Rolling Meadows Substation
Construction of a New Electrical Substation
including Grading, Drainage, and Surface Improvements
El Paso County, Colorado

PCD FILE NO. PPR 2619

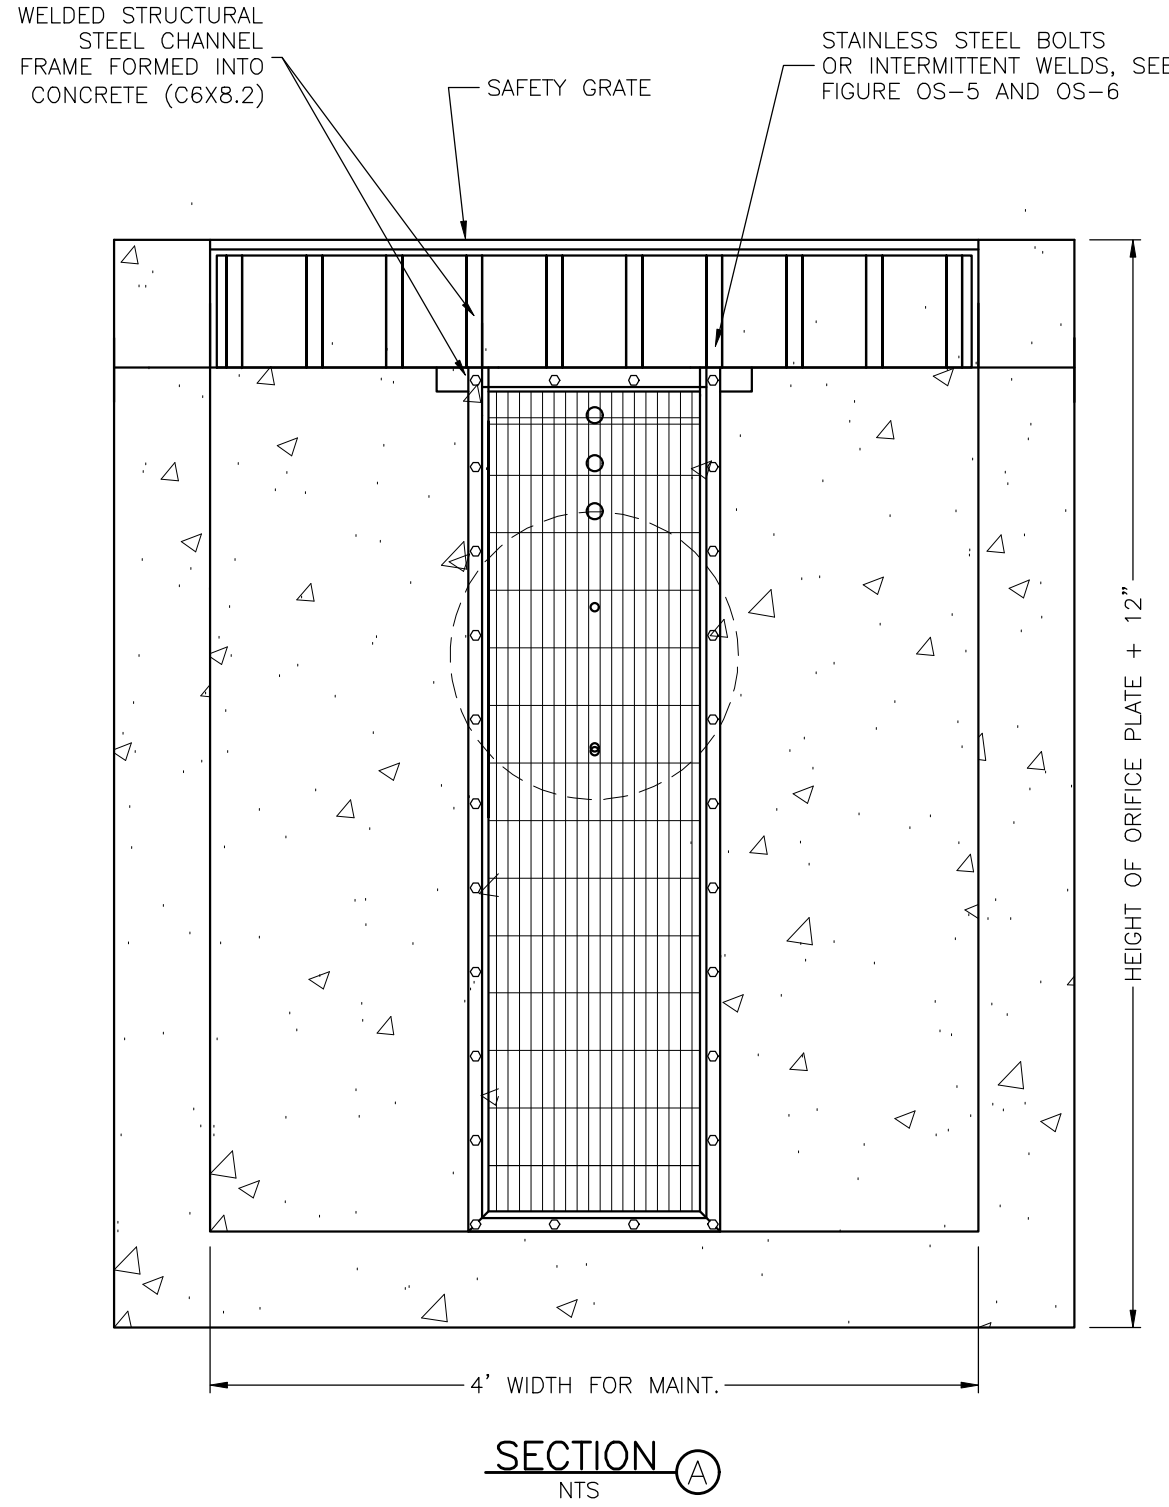
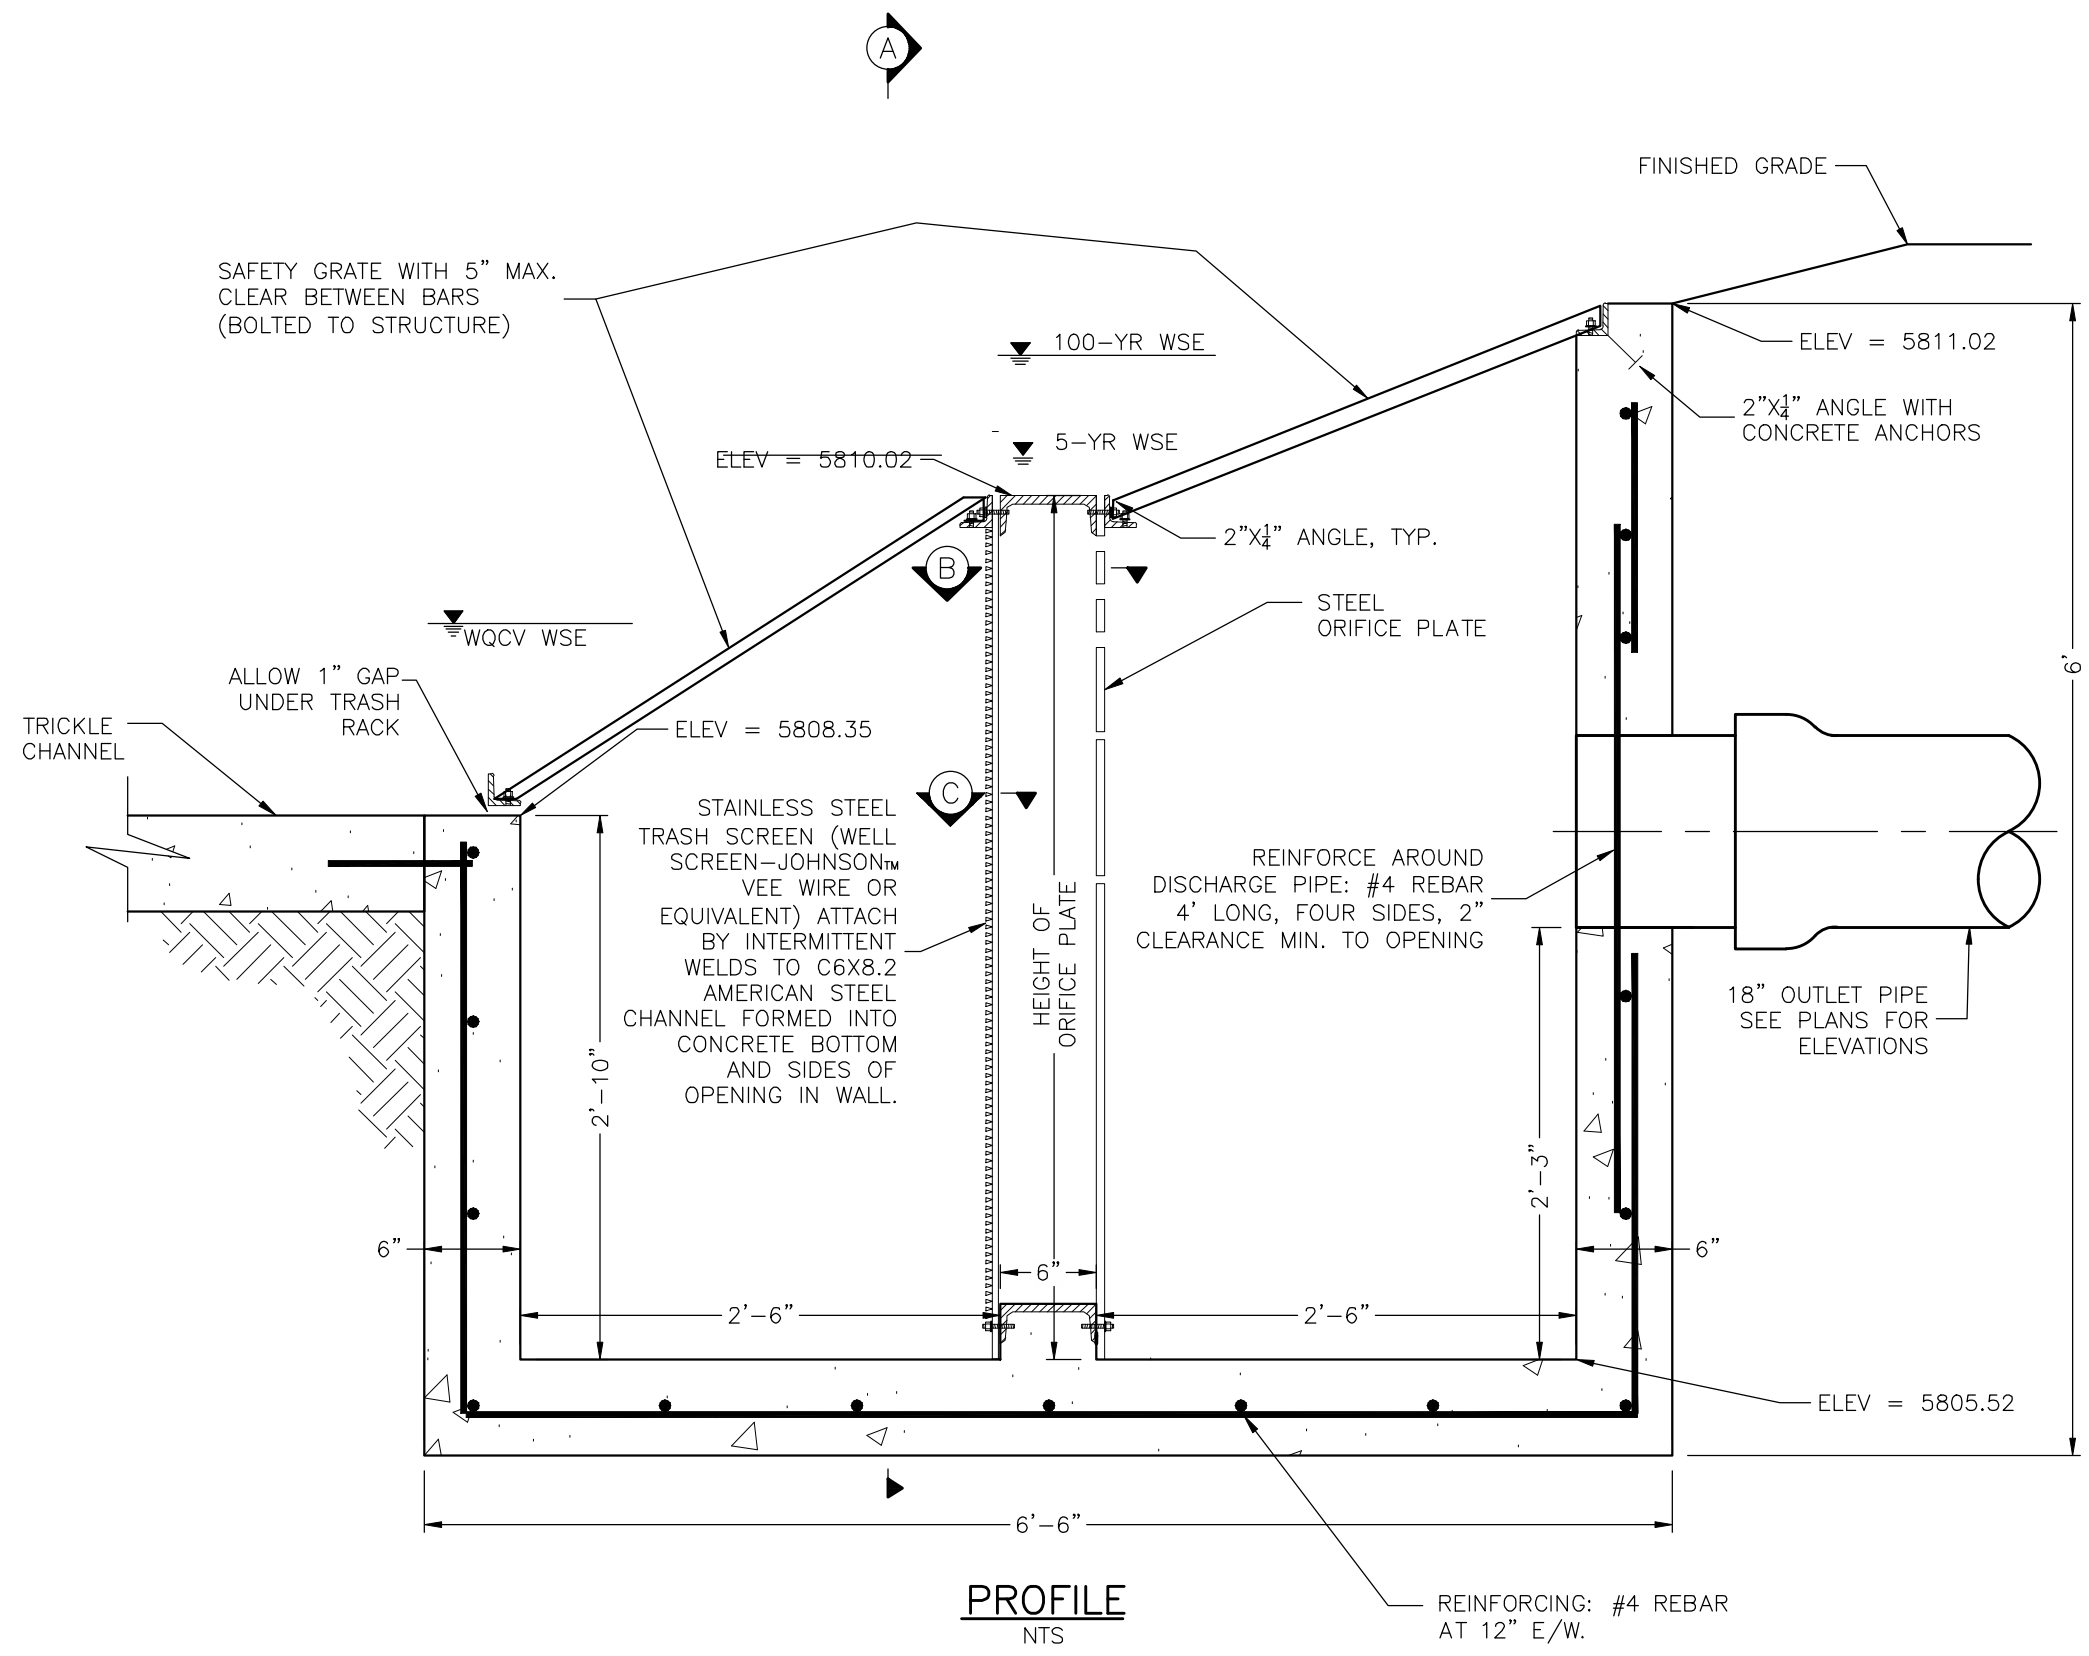
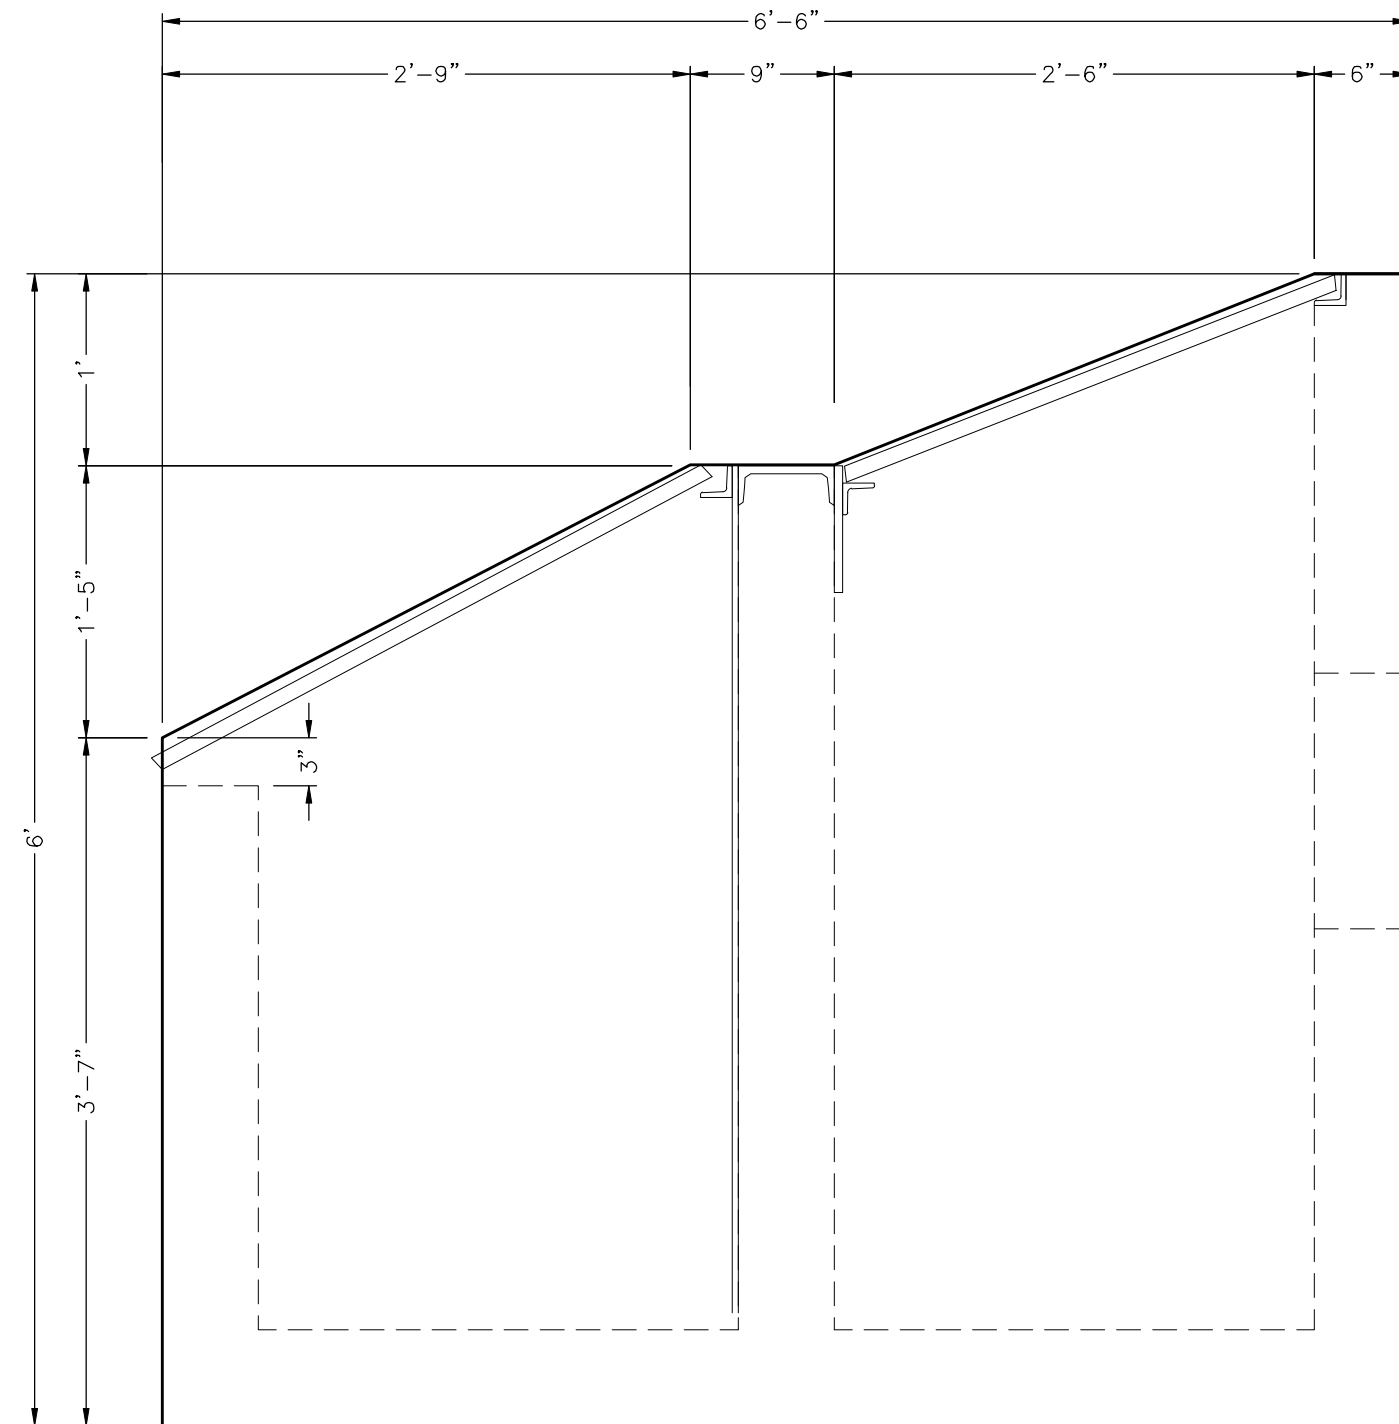
Per calcs this should be 5811.1. The calcs show the spillway invert at 3.08 ft from stage = 0 (3808.02).
